The Sizewell C Project

**Natural England's Response to The Examining Authority's Request
for Written Responses from Issue Specific Hearing 10**

Planning Inspectorate Reference: EN010012

17th September 2021

DRAWING TITLE:
 FIGURE 1.1
 WESTLETON MARSH HARRIER COMPENSATORY HABITAT LOCATION

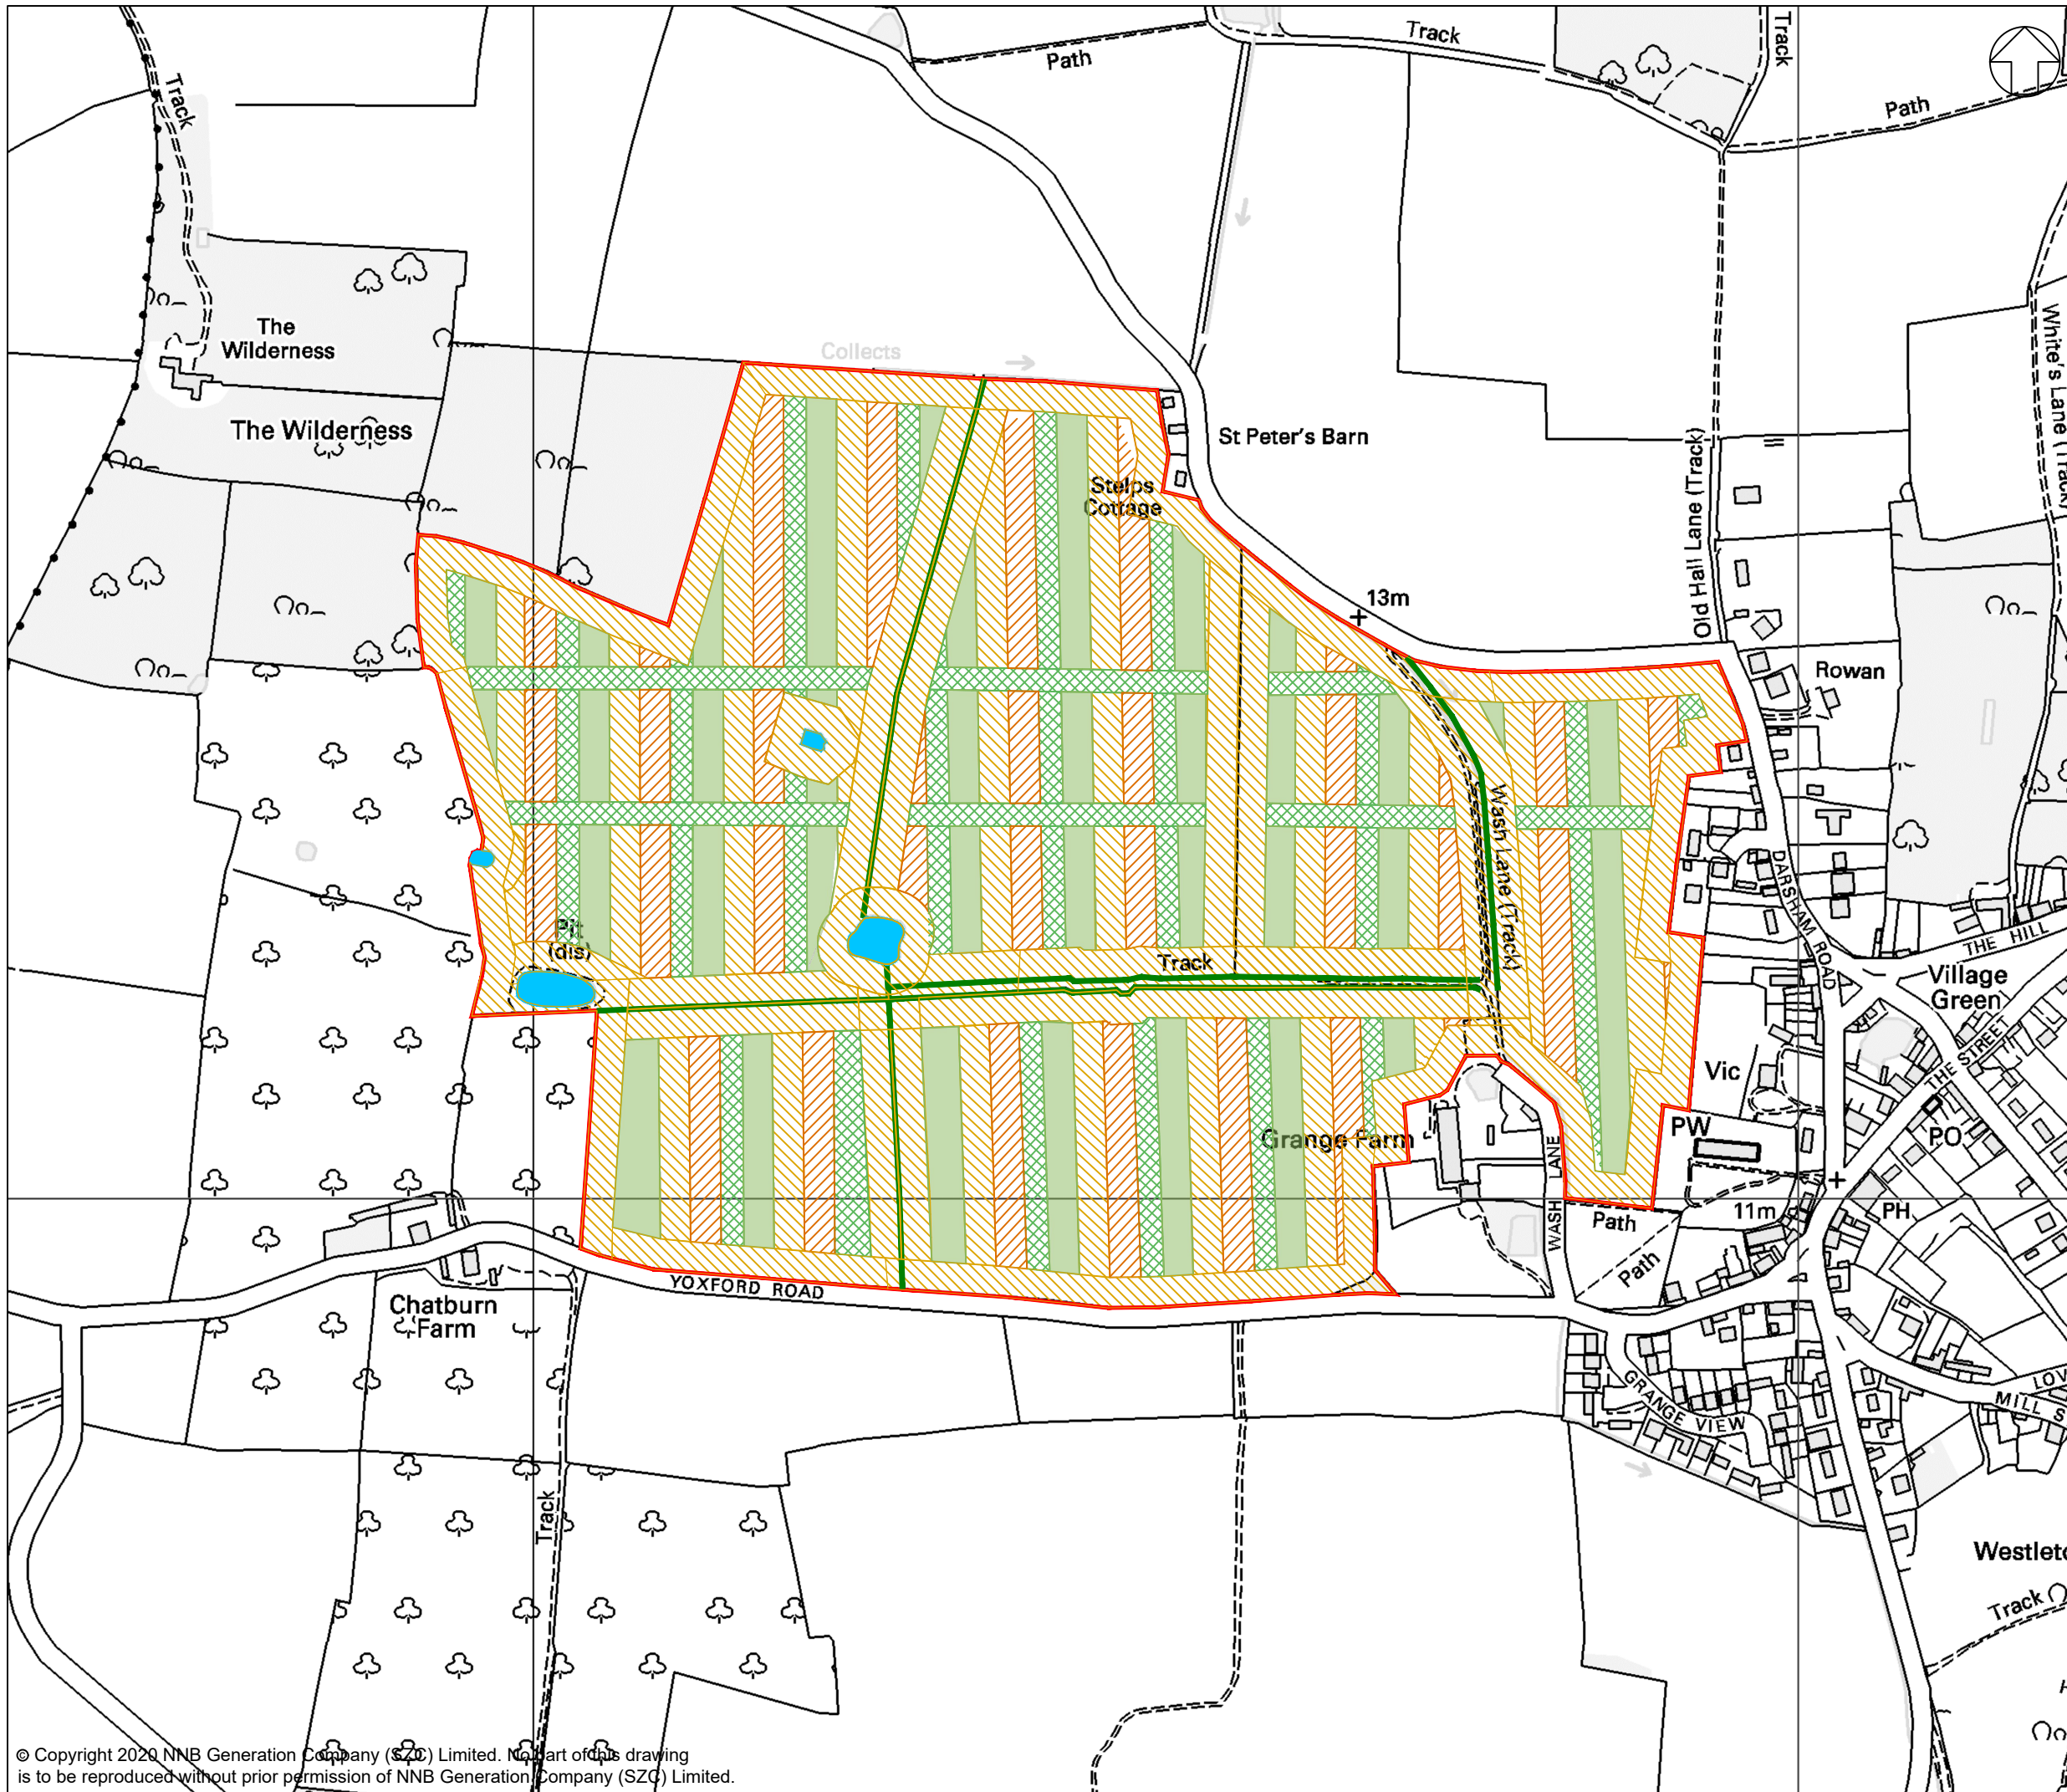
- 5.8. The primary consideration when attempting to create habitat for foraging marsh harriers is to identify a location where it is feasible to create the type of wetland habitat the species favours. The Applicant disregarded the potential to create optimal wetland habitat as they stated this was not feasible close to the SPA:

- 5.8.1. Natural England has engaged with the Applicant to address effects on marsh harriers since 2014. Over six years, Natural England has provided advice to the Applicant to assist with their experimental approach to create sub-optimal terrestrial habitat for marsh harriers, rather than optimal wetland habitat, on an in principle basis i.e. the Applicant’s assurance that creation of wetland habitat was not possible.

- 5.8.4. This constraint narrowed the Applicant’s area of search for habitat creation, as moving too far away from the SPA to find a location where the hydrology was suitable for wetland creation, might also be too far away from foraging SPA birds. Moving further away would make it increasingly difficult to exclude the potential for adverse effect on site integrity beyond reasonable scientific doubt.

- 5.8.5. The applicant confirmed there was nowhere close enough to the SPA where habitat creation could be deemed mitigation that had suitable hydrological conditions to create wetland.

- 5.8.8. Finally, at Issue Specific Hearing 10 Session 4 27th August, Natural England was made aware of evidence provided by Roger Buisson (Associate Director at BSG Ecology) in relation to his client’s 53ha land holding close the SPA where wetland habitat for marsh harriers could be created.
